From: Anita Gardner
Sent: 10 January 2012 14:08
To: Ian Brewster
Subject: RE: CL/11/11/DOC - Application to discharge condition 6 of planning condition CL/11/10, Merrie Gardens, Long Furlong, Clapham

0311/SP01 A

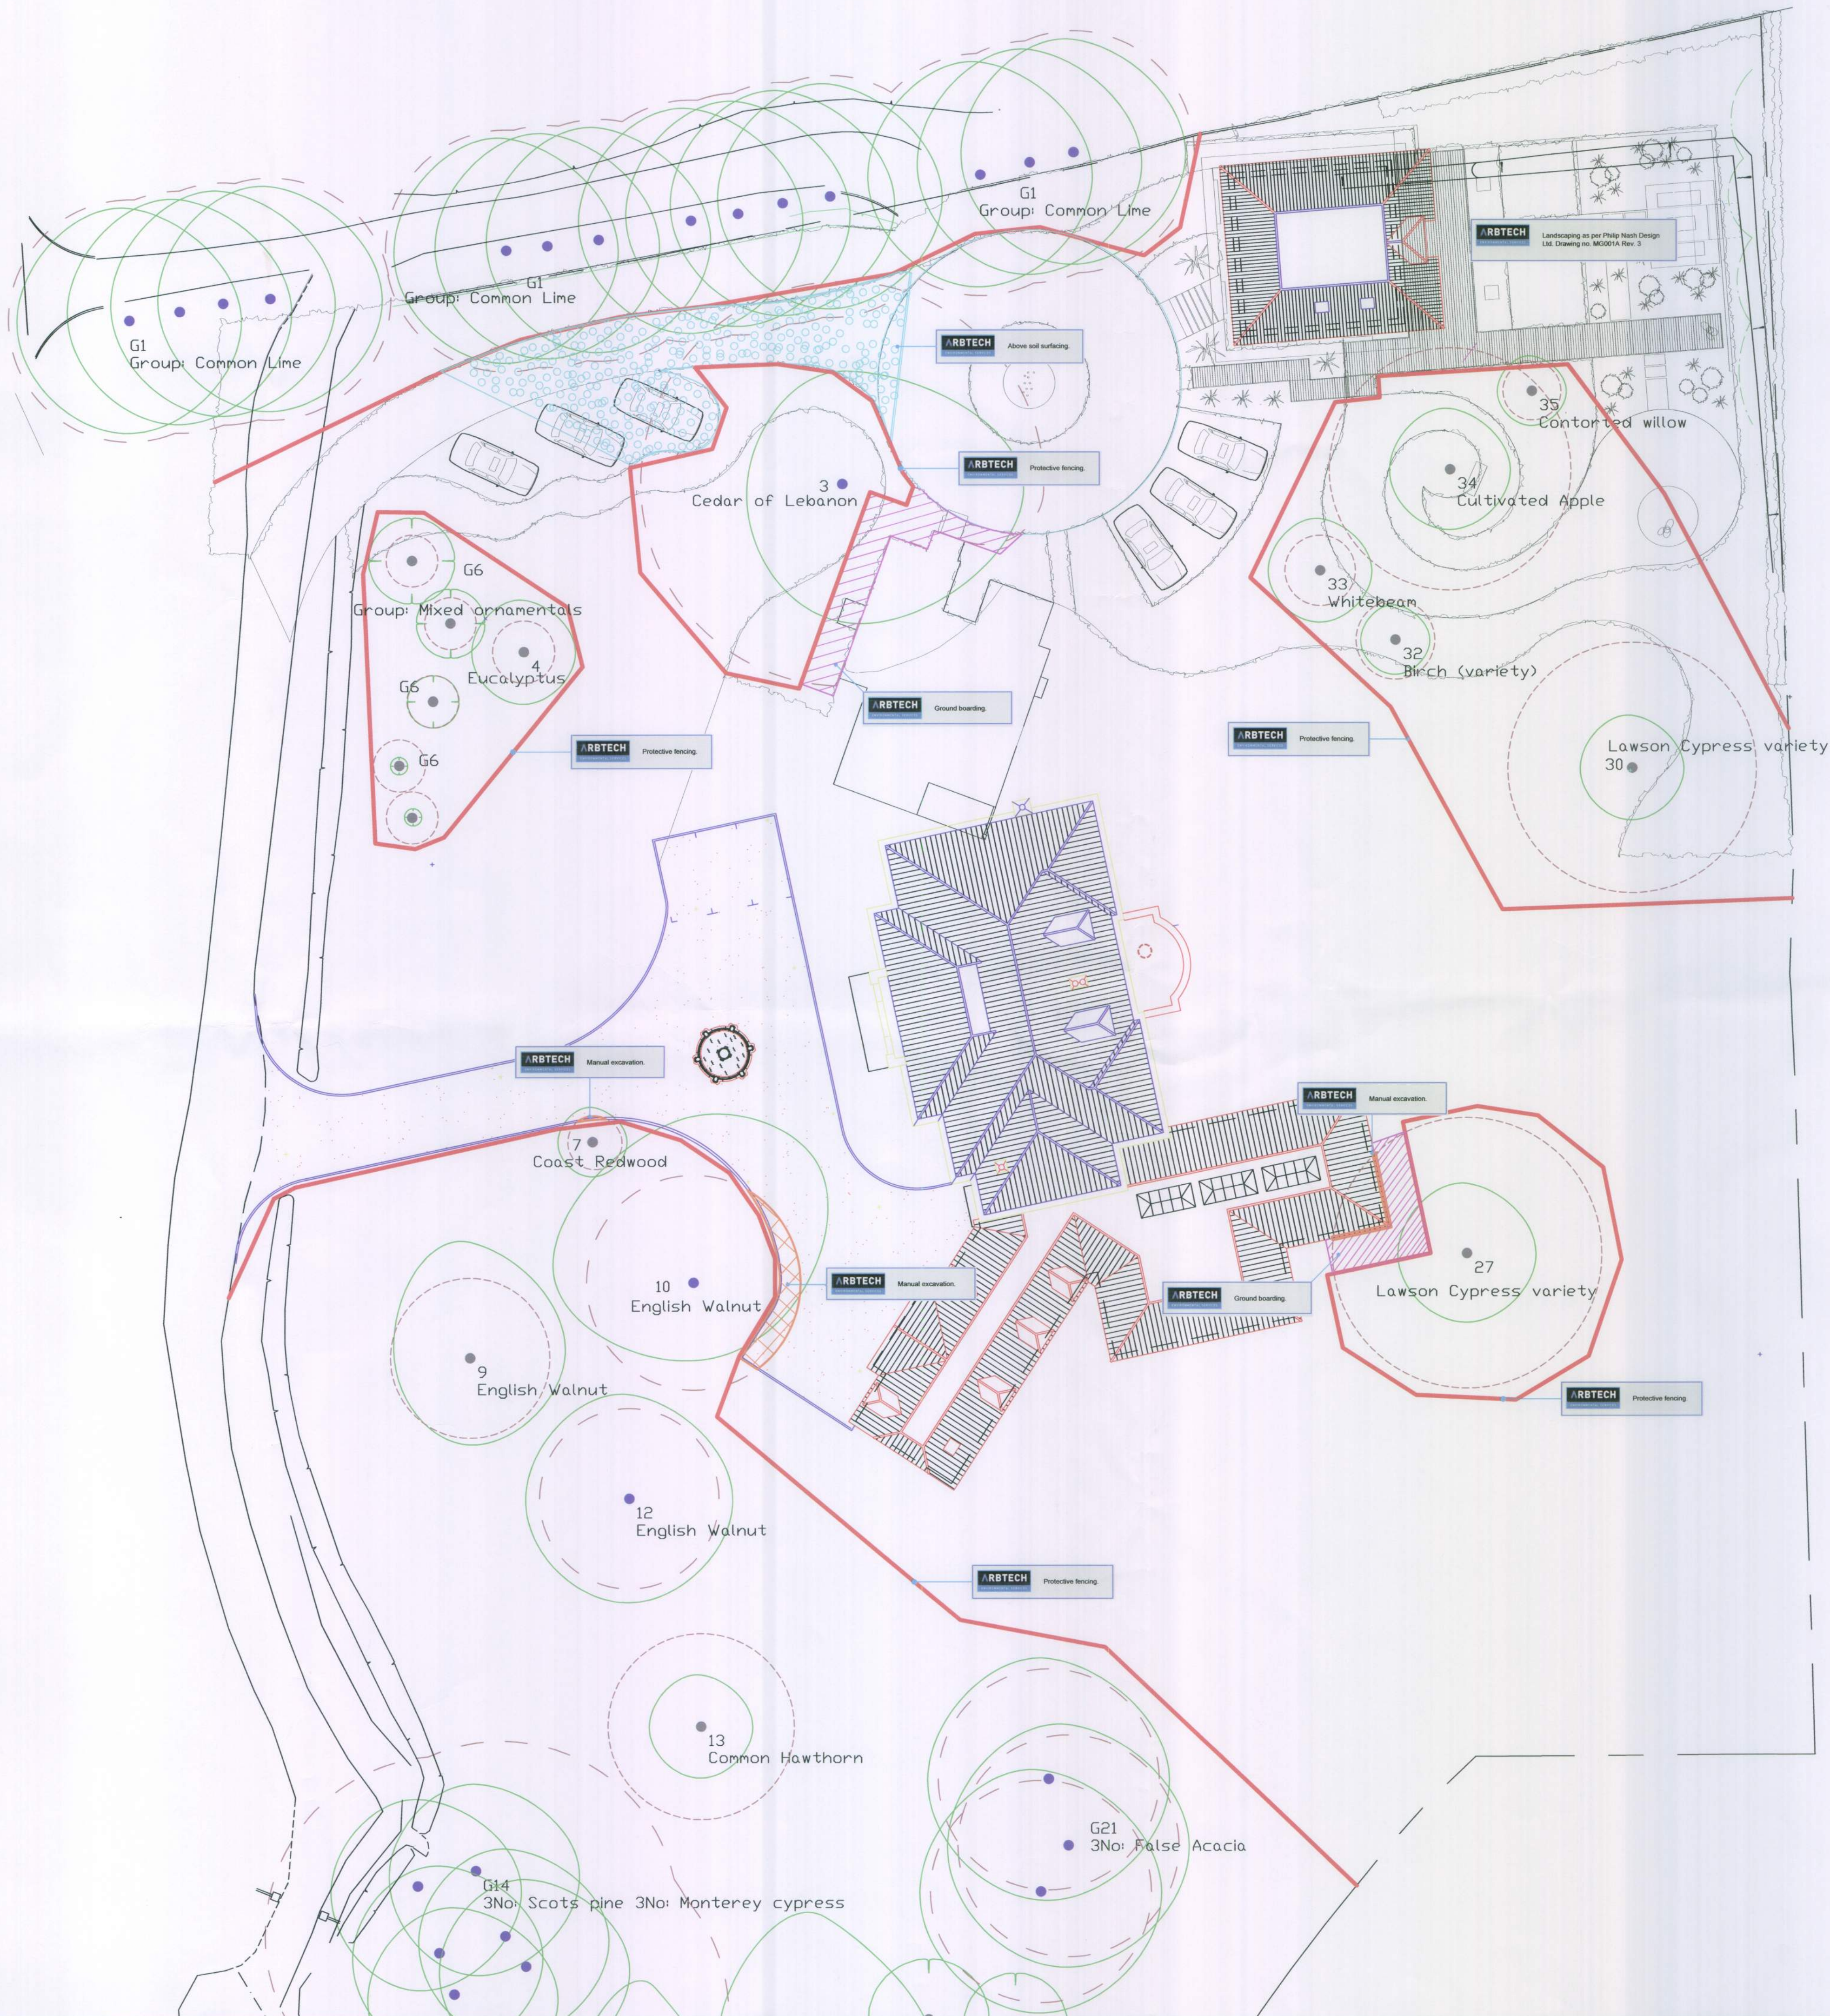
With regard to long term piling/raising of soil (depending on soil type), tree roots may eventually grow and establish within this area and removing to original levels may cause more harm unless the soil is removed manually within a shorter period.

I inspected the above site last Friday afternoon (6th January). See pictures taken on that date attached above to show heavy vehicular movement and trenching within the Root Protection Areas of trees subject

to retention / fencing protection according to the Planning Conditions. Condition 6 has not been implemented and adhered to and therefore this cannot be discharge.

I have checked our files. Since works to implement this permission have not started I can't refuse to discharge the condition on the basis of movement of heavy vehicles and piling of soil in root protection areas in what is essentially a domestic garden with no preserved trees. I therefore propose to discharge the condition, but advise that the works undertaken within Root Protection Areas would not be acceptable when development commences and request that in the interests of the health of the trees and their long term retention the soil is removed and vehicle movements restricted.
